From: Contact Centre (CRM) <contact@ribblevalley.gov.uk>
Sent: 04 September 2024 00:13
To: Planning
Subject: Planning Application Comments - 3/2024/0530 FS-Case-643717149

Planning Application Reference No.: 3/2024/0530

Address of Development: Cockshotts Barn development

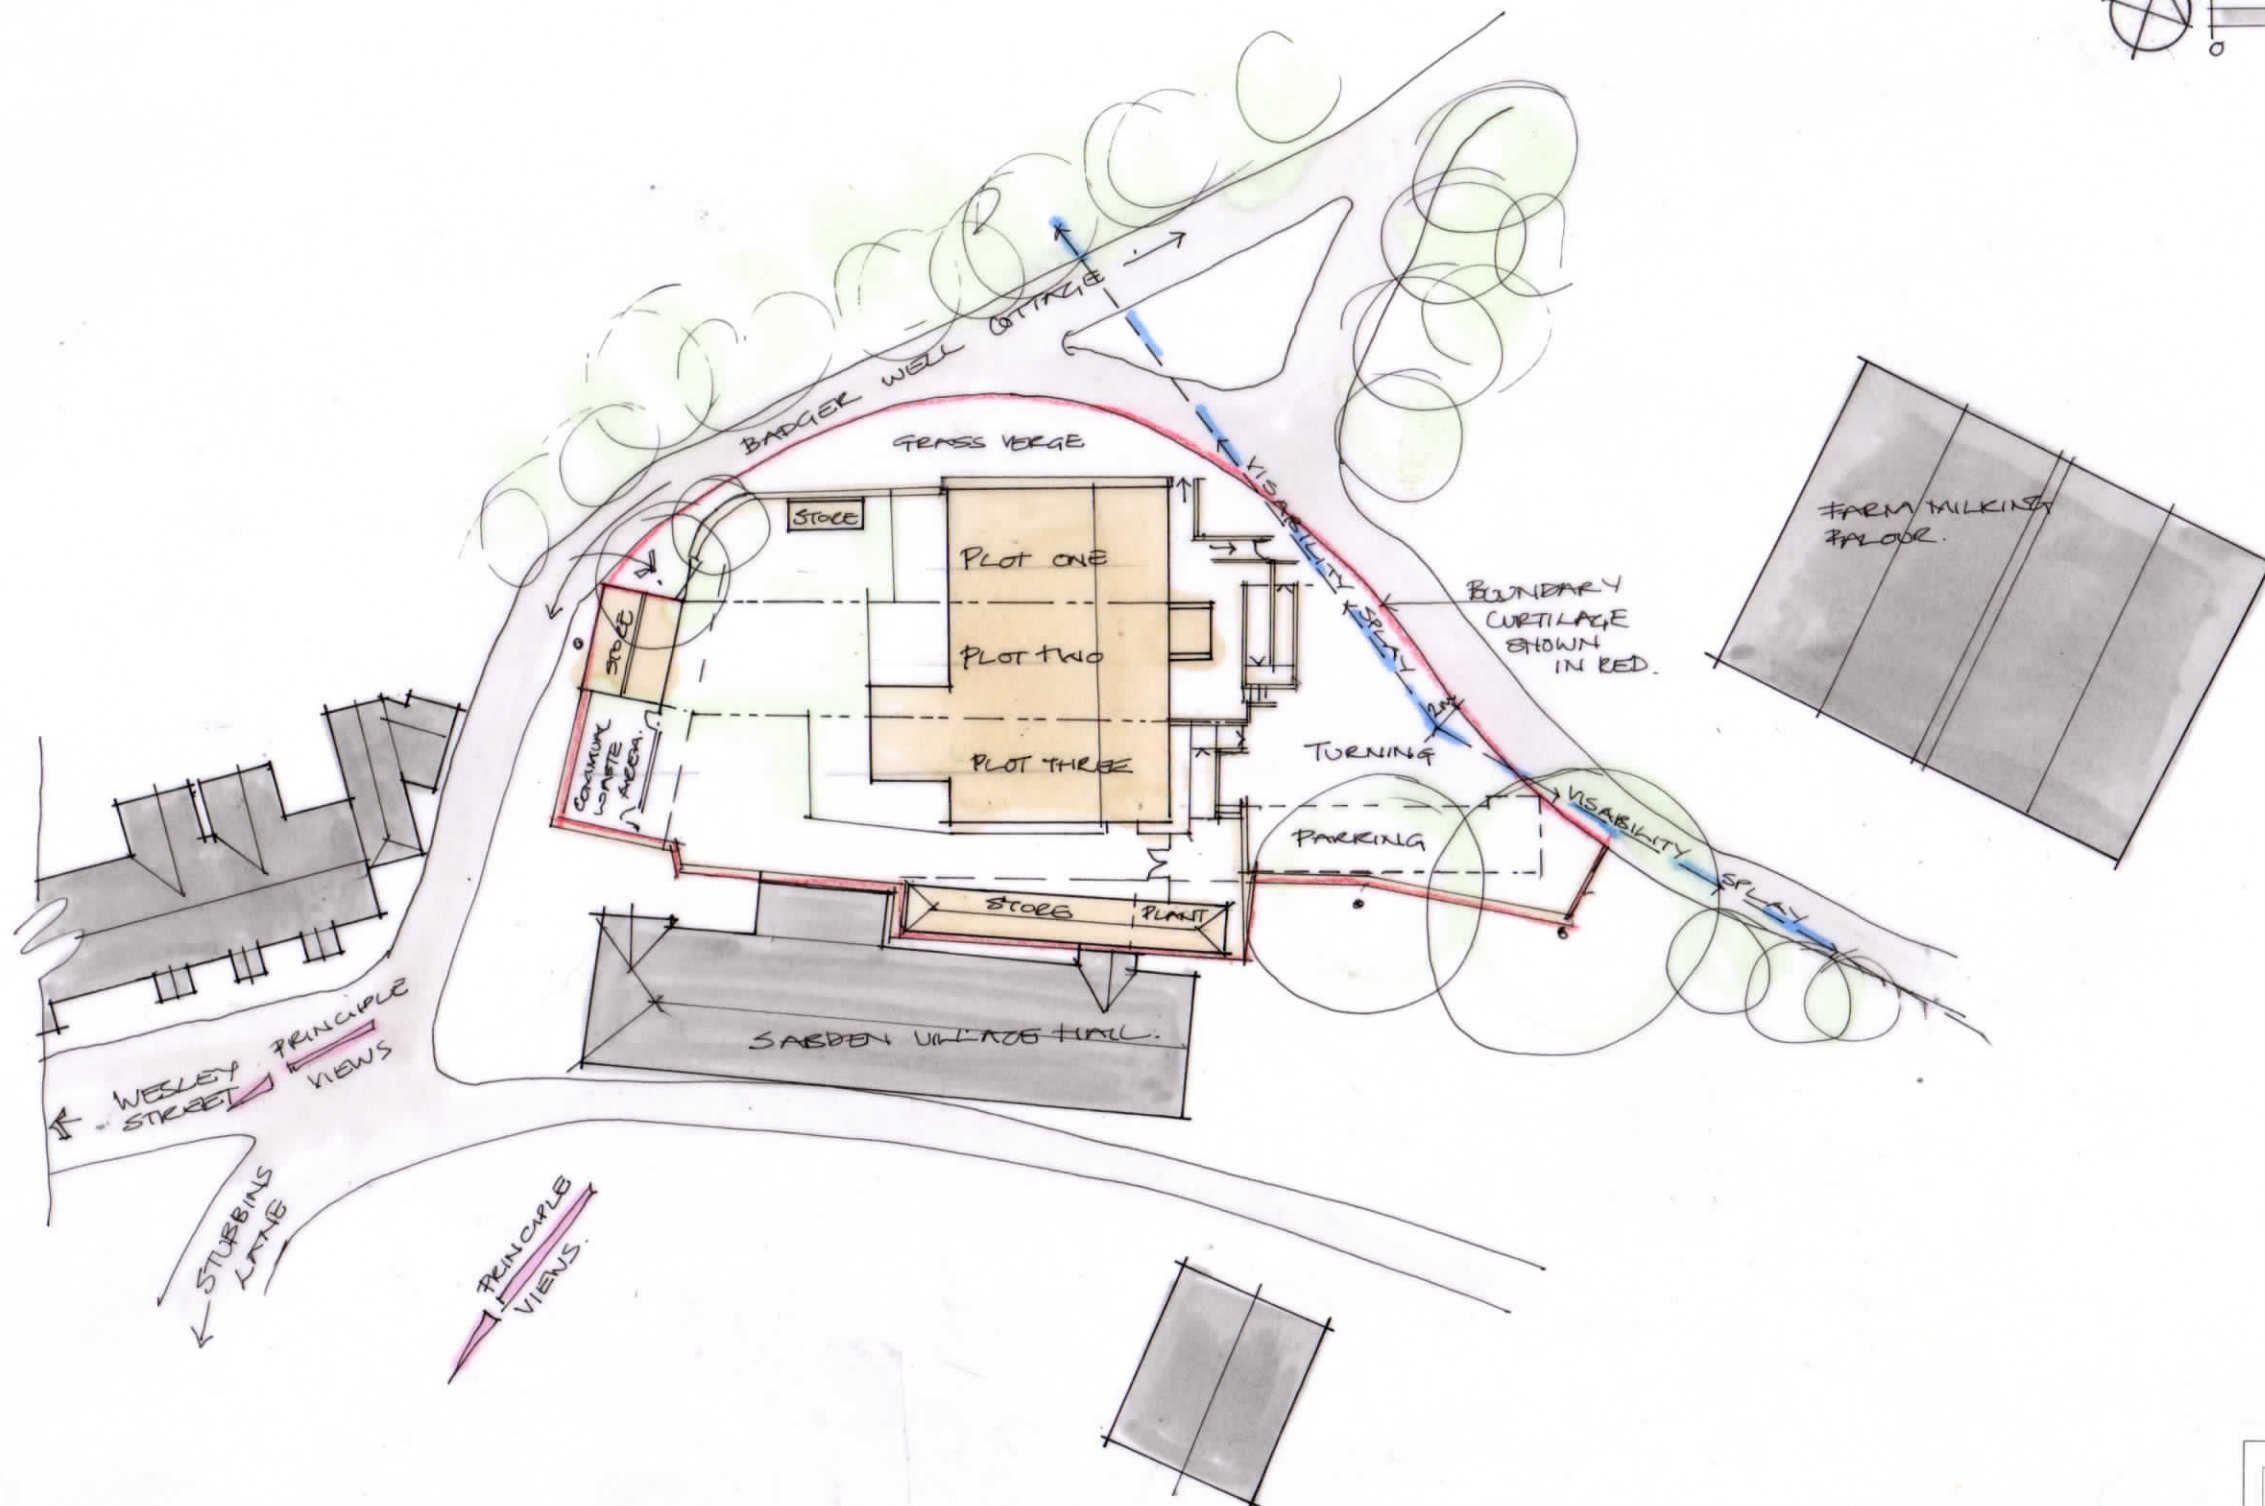
I am concerned that 2 parking spaces per large home with 1 shared 'other' space does not leave many options for visitors to park. The proposed redevelopment is a distance from the public car park on Padiham Road. Any on-street parking would cause issues for either the nearby farm or for residents on the already congested Stubbins Lane and Wesley Street. If this can be mitigated at the planning stage then I feel this development will be a positive gain for housing stock in Sabden.
